<b>Consultation Response from: KC Environmental Health (Pollution &amp; Noise Control)</b>		
<b>2021/93674 Greenhead College, Greenhead Road, Huddersfield, HD1 4ES</b>		
<b>Partial redevelopment of Greenhead college including demolition and making good, erection of 2 and 4 storey buildings, reconfiguration of parking and access arrangements, reconfiguration of sports provision and other associated external works (Within a Conservation Area)</b>		
<b>Date Responded: 9th November 2021</b>	<b>Responding Officer: Rebecca Muff – Air Quality Natalie Heaney – Contaminated Land</b>	<b>Responding Ref: WK/202133587</b>
<p>This application is for the partial redevelopment of Greenhead College which is located in a predominantly urban residential area of Huddersfield. The site is bordered by Park Drive South and Greenhead Park (a grade II listed park) to the north, and Greenhead Road and Park Avenue to the south and east. The proposal is for the demolition of part of the existing central buildings and the erection of a new science block including a dining area and associated kitchen. External works include the reconfiguration of the existing sports pitch to a new all-weather sports pitch and t

Figure 7: Noise barrier to the roof level plant area west elevation

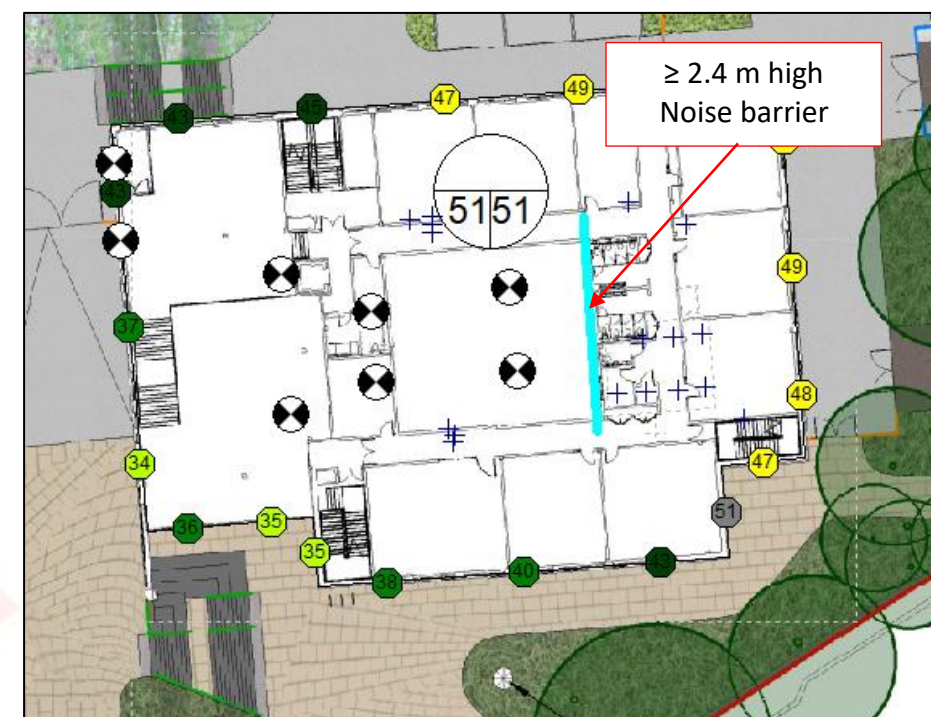
(3) The report reads, *'The details of proposed building services plant including operating mode and noise data are subject to detailed design and were not confirmed at the time of writing. Further assessment will be undertaken when these details are confirmed'*. The report then continues to recommend an acoustic barrier and indicate that *'additional acoustic treatments'* may be necessary.

No finalised information relating to the proposed plant has been received, unit positioning or any features which may influence the acoustic impedance have been noted. Furthermore, no information has been provided relating to the operation times of all the fixed plant units, and the expected combined noise from any existing and proposed units. As such it is unclear what noise levels will be produced by the units and the noise it will create at nearby noise sensitive locations. Ultimately in the absence of this information, we agree that further assessment is required to confirm whether mitigation measures are necessary.

Figure 8: Noise barrier to the west and south of the sports pitch

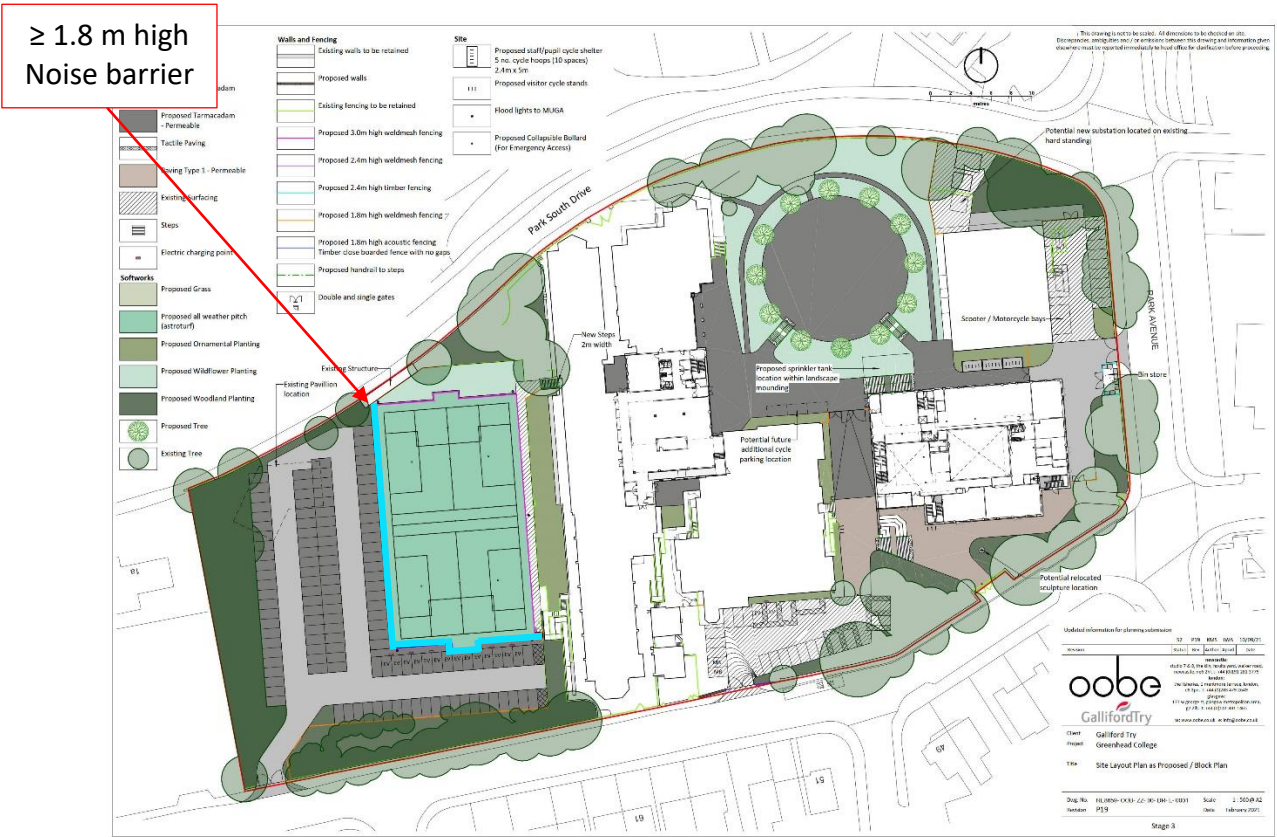
(5) We note the proposals for a close boarded timber fence such as an acoustic barrier around the west and south of the sports pitch. Any fencing to the pitch must be anti-rattle fencing. For the reasons detailed herein, a revised noise assessment and revised proposals for attenuation measures are necessary.

Figure 9: Statistical analysis of the background sound levels measured during daytime (07:00-23:00)

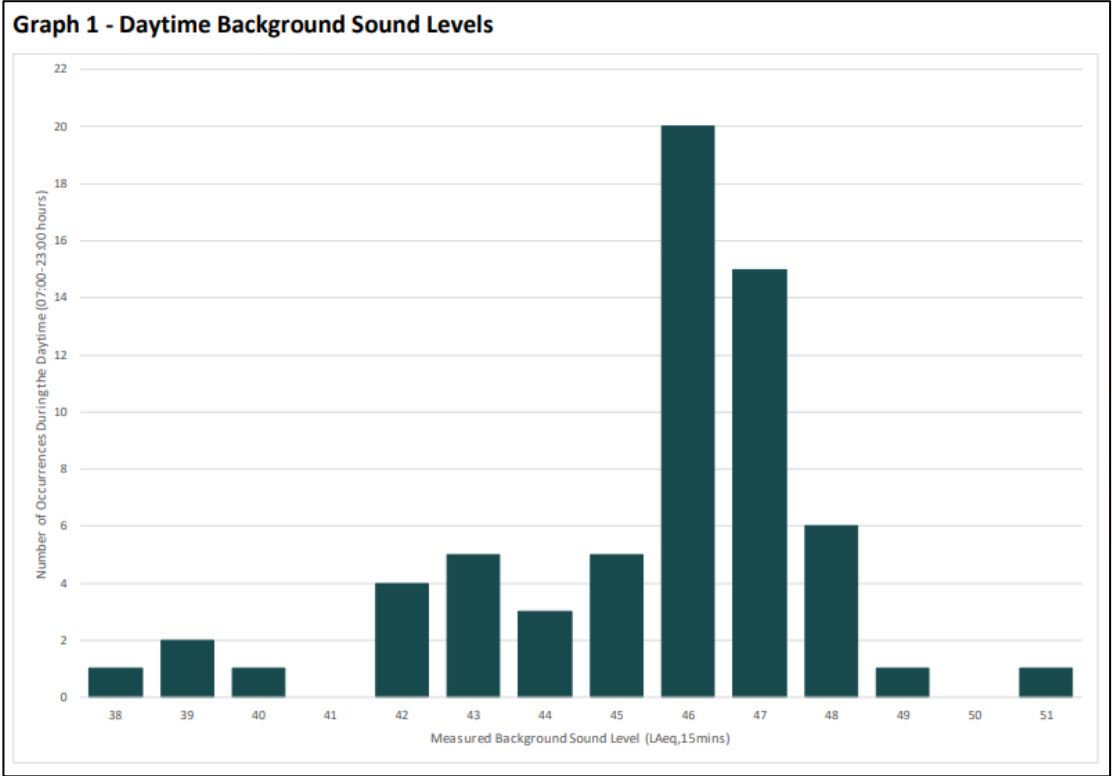
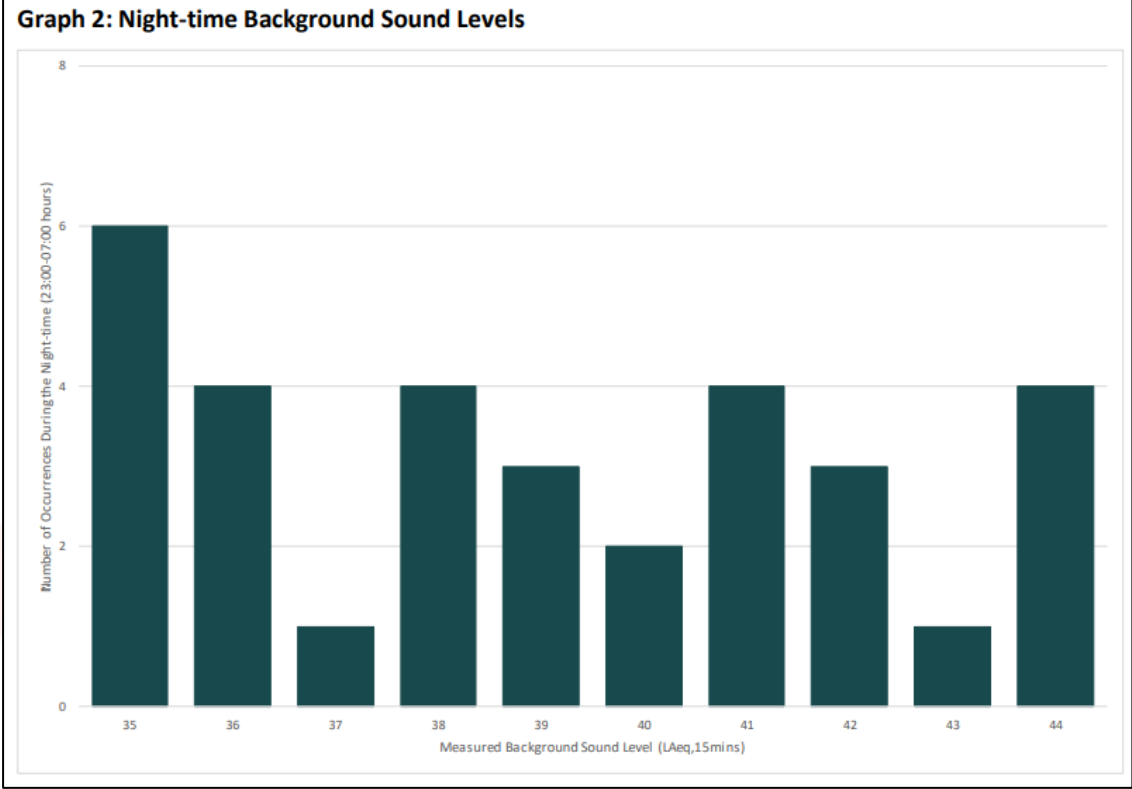
(6) The time of the noise measurements referred to in Section 7.9 of the report i.e. 12:30 to

17:00 hrs appears to contradict the information provided in Appendix B. In Appendix B, it is detailed that background sound levels were measured between 07:00 and 23:00hrs (daytime) and then 2300hrs to 0700 hrs (nighttime). In order to provide a robust noise assessment, background noise levels must be clearly indicated. Please clarify the actual background noise levels. Without this information we cannot confirm the validity of the report conclusions.
